From: Melizza Morales
Sent: Thursday, 28 February 2019 11:19 AM
To: Scott Hay
Cc: Erin White; Emma Kirkman; Media Hakim
Subject: Notice of exhibition - Kyeemagh Public School (SSD 9391) - GA

On 11 February 2019, the Department of Planning and Environment invited GANSW to review and provide comment on the EIS for Kyeemagh Public School. The proposal was presented to the SDRP on 12 December 2018 and the outcomes of the review were incorporated into the advice provided to the proponent on 21 January 2019. The review of the EIS is made in relation to that advice.

Educational Facilities Guidelines require a min of 300 lux in learning spaces

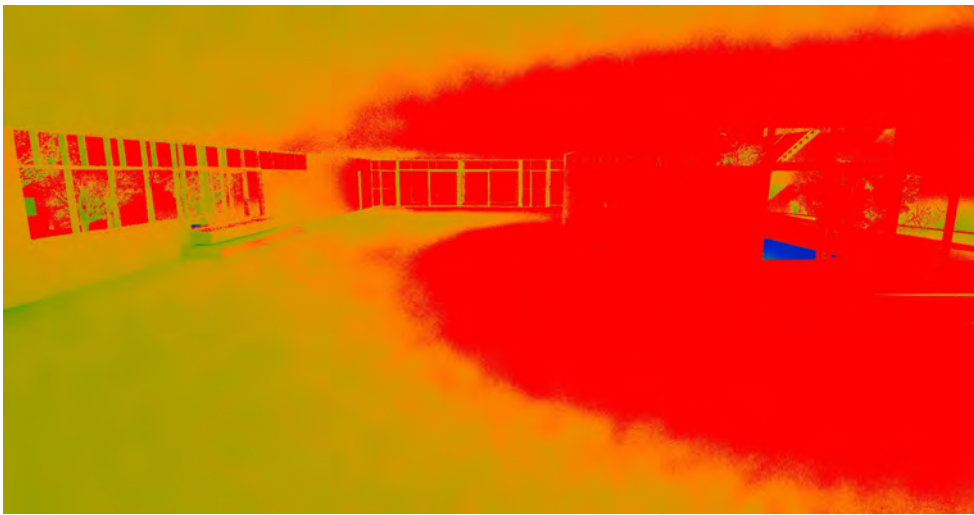
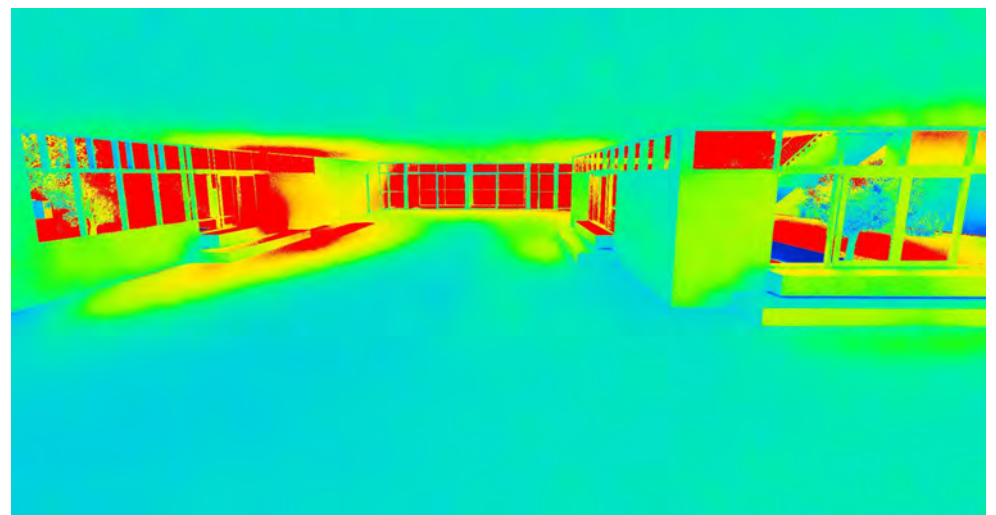
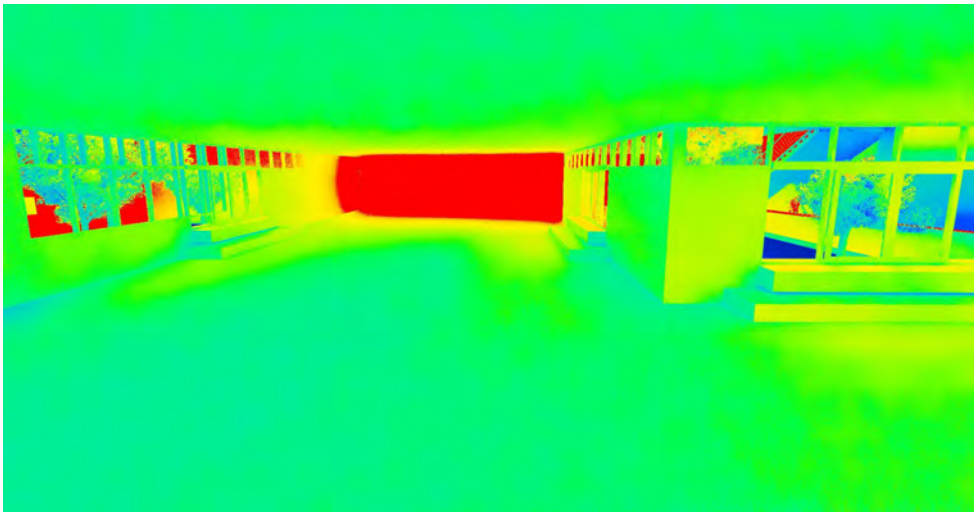
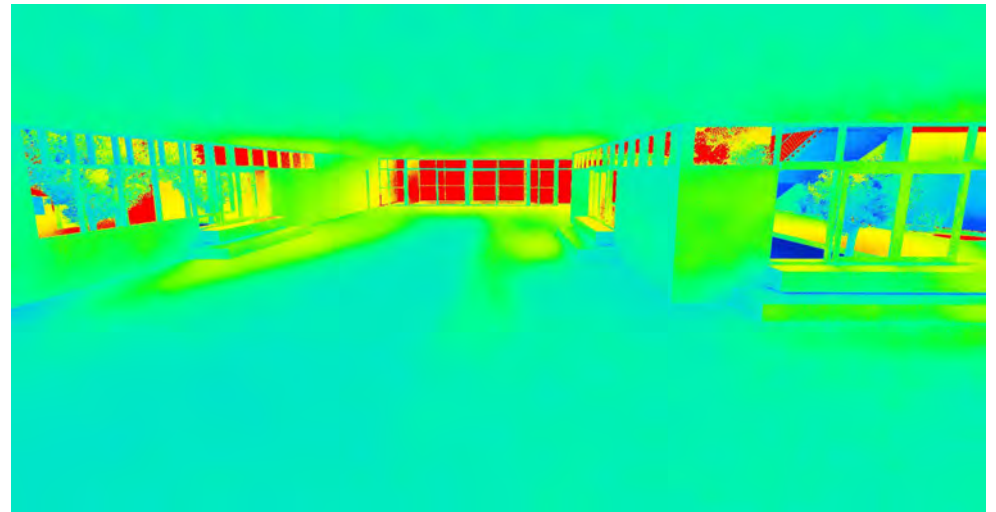
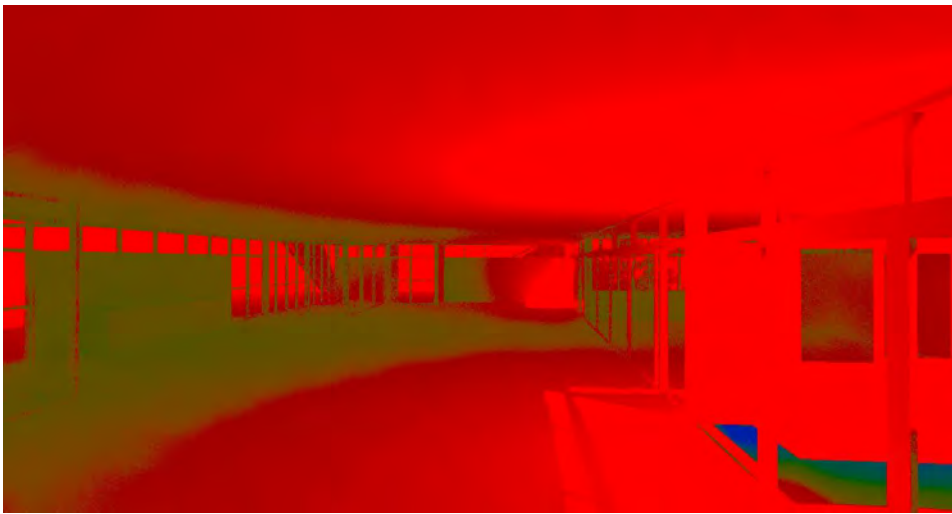
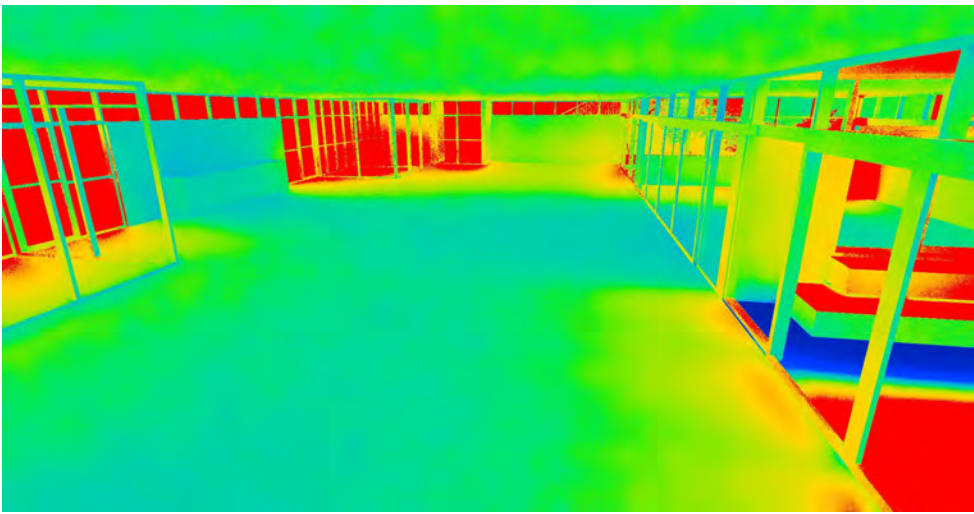
- b) In response to our objection to the way the home bases are proposed to be expanded, the proponent states that the expansions have been approved by the Educational Facilities Standards and Guidelines. The proponent also states that light penetration has been modelled and deemed to be appropriate.

- modelling showing the appropriate light penetration to the expanded home bases and adjacent spaces (addressing item b) above)
- an Aboriginal Cultural Heritage Strategy demonstrating that the use and interpretation of Aboriginal content will be done in a way that is respectful to Country. This should include the nominated cultural advisor for the design and any relevant permissions to use Aboriginal narratives and/or art on the building facades (addressing item c) above).

Aboriginal cultural heritage

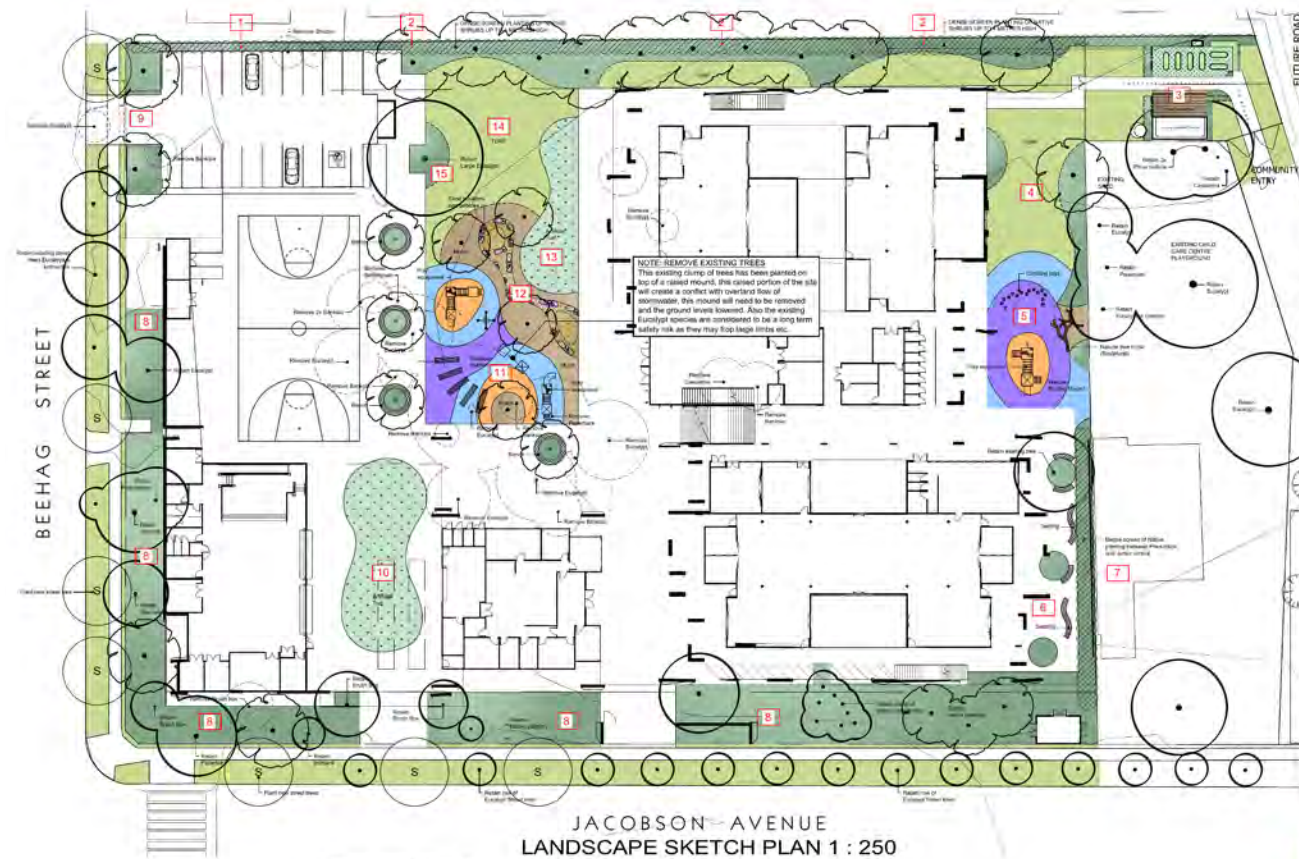
- c) In response to our requirement for a response to the site's Aboriginal cultural heritage, the proponent explains that their *"consultations with Aboriginal Heritage Groups has not identified any specific relevance or connection that the site has to Aboriginal culture"*. However, they propose to adopt an Aboriginal theme for the design of the landscape and use Aboriginal art on the Beehag façade.
